Application for a Non-Material Amendment Following a Grant of Planning Permission

Development: Non material amendment following grant of BR/34/20/PL to retain the garage door on the front elevation and to change the roof design to the single storey rear extension to a full gable end.

Location: 102 Linden Road Bognor Regis PO21 2BD

BR.01

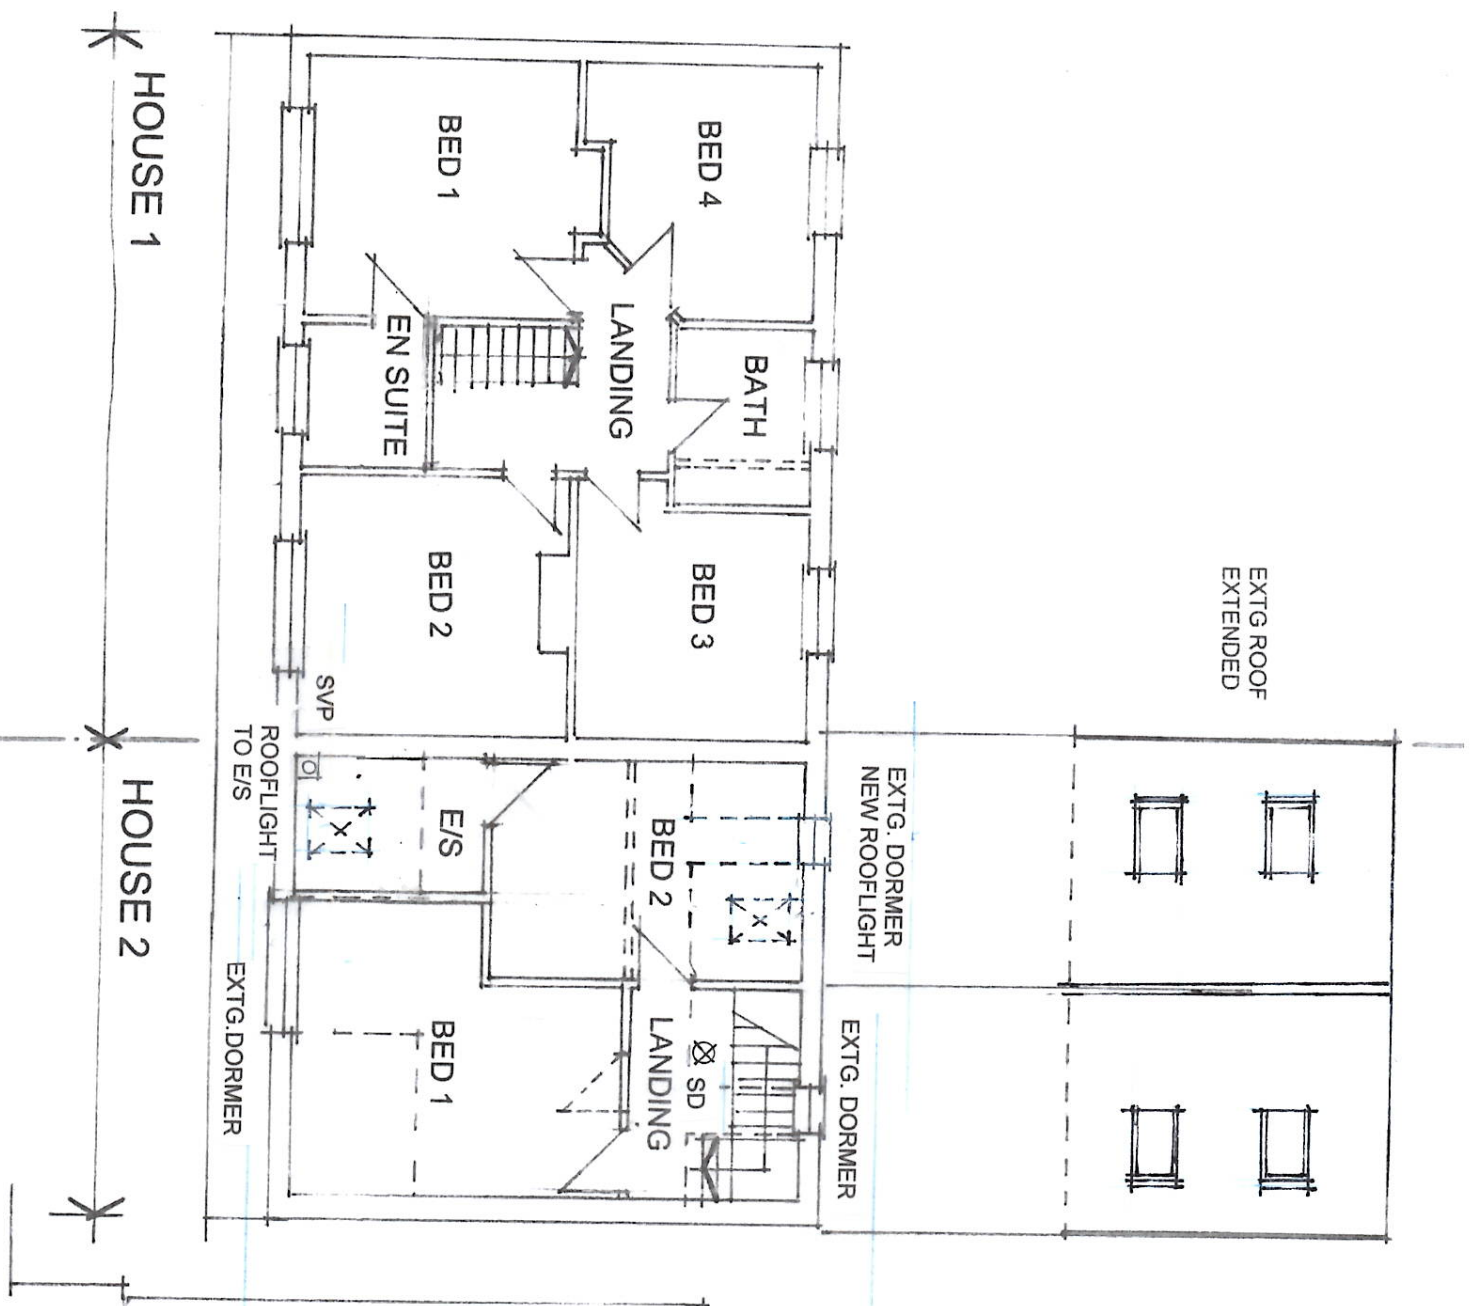
Dwg No BR.01 does not appear to scale correctly, the scale bar measures 9.6m. Please check, amend accordingly and re submit.

102 LINDEN ROAD
BOGNOR REGIS
JOB NO. 19.1135
DRG. NO. BR.02

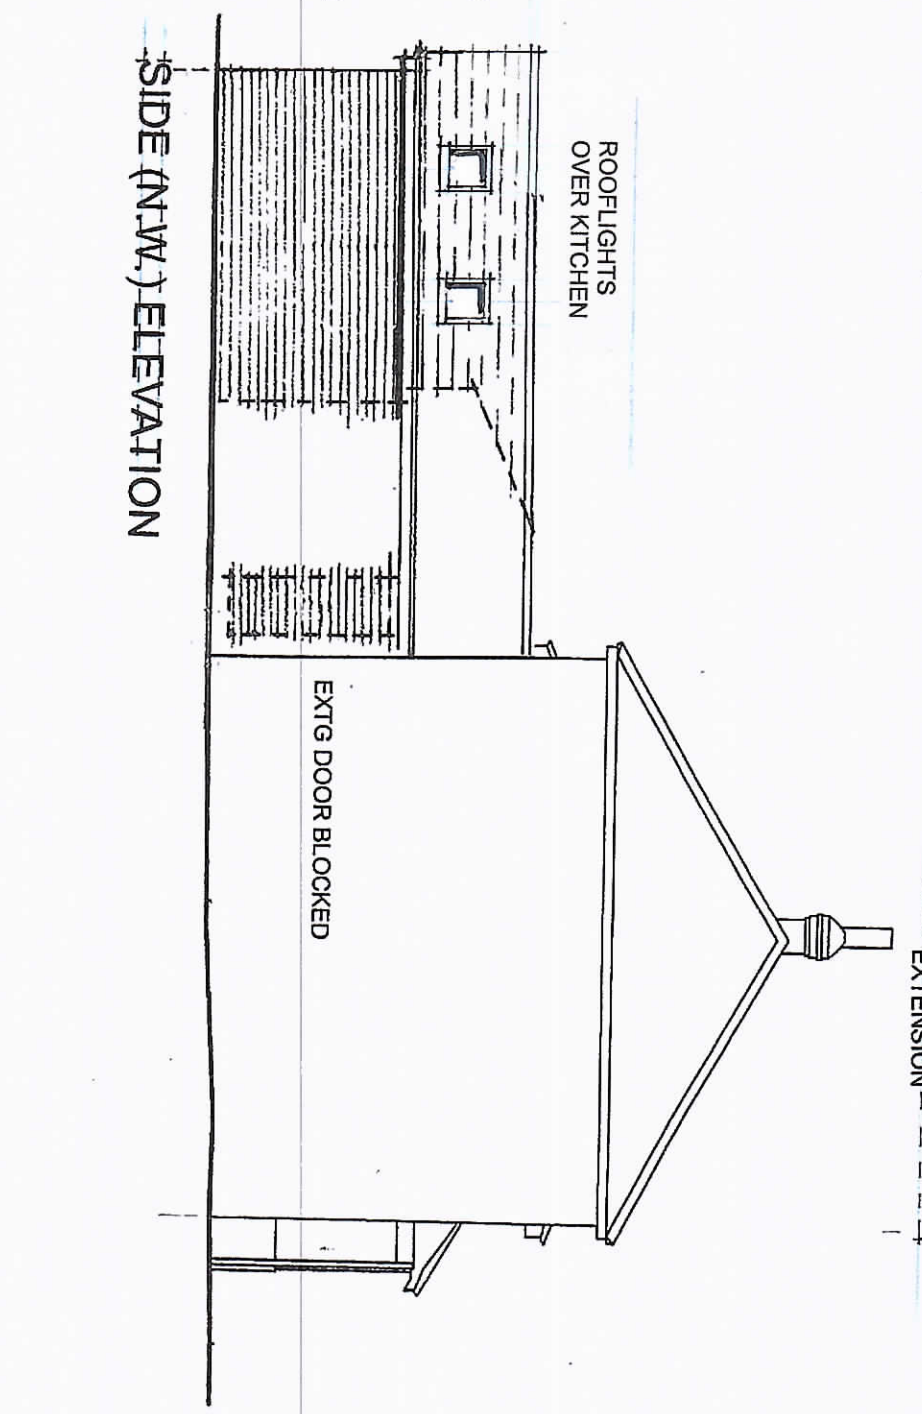
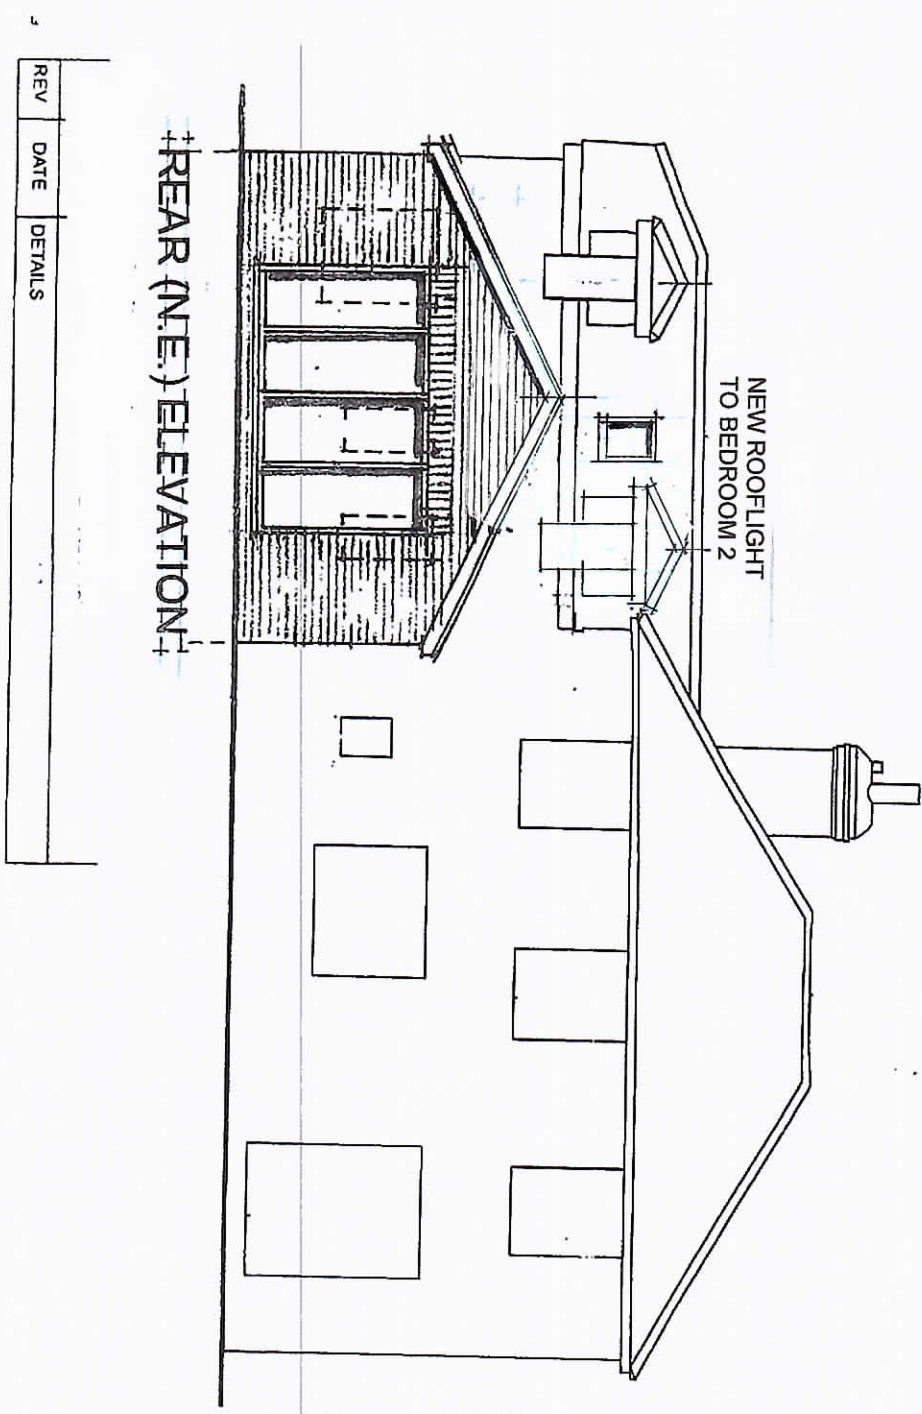
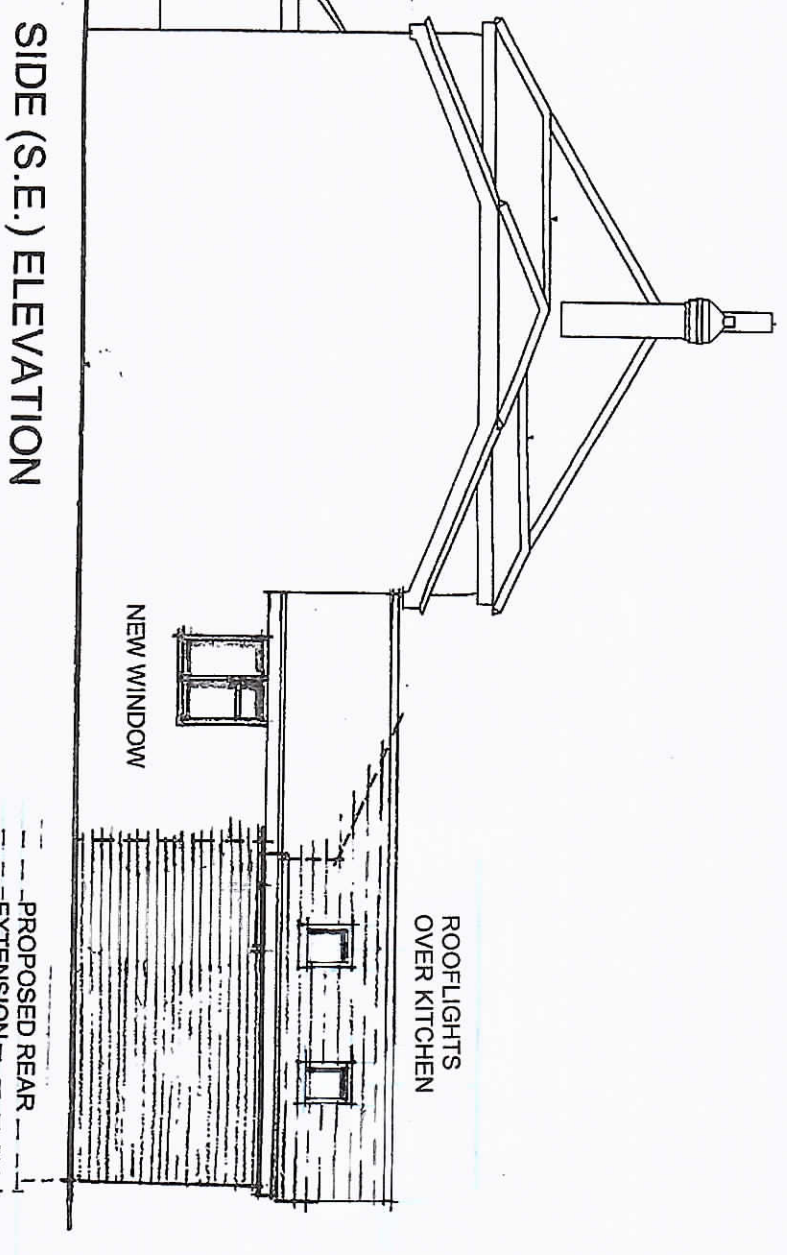
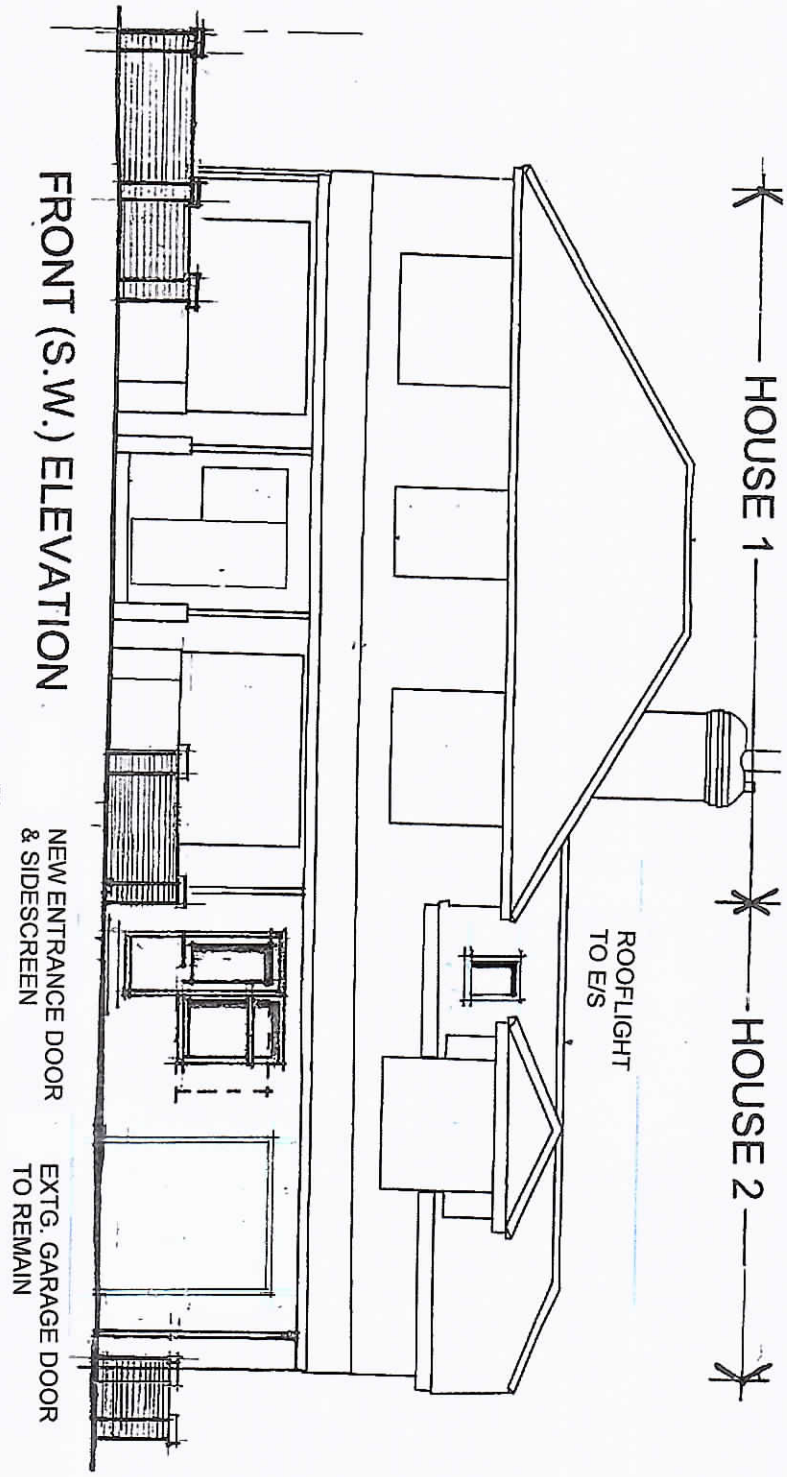
Dwg No BR.02 does not appear to scale correctly, the scale bar measures 9.8m. Please check, amend accordingly and re submit.
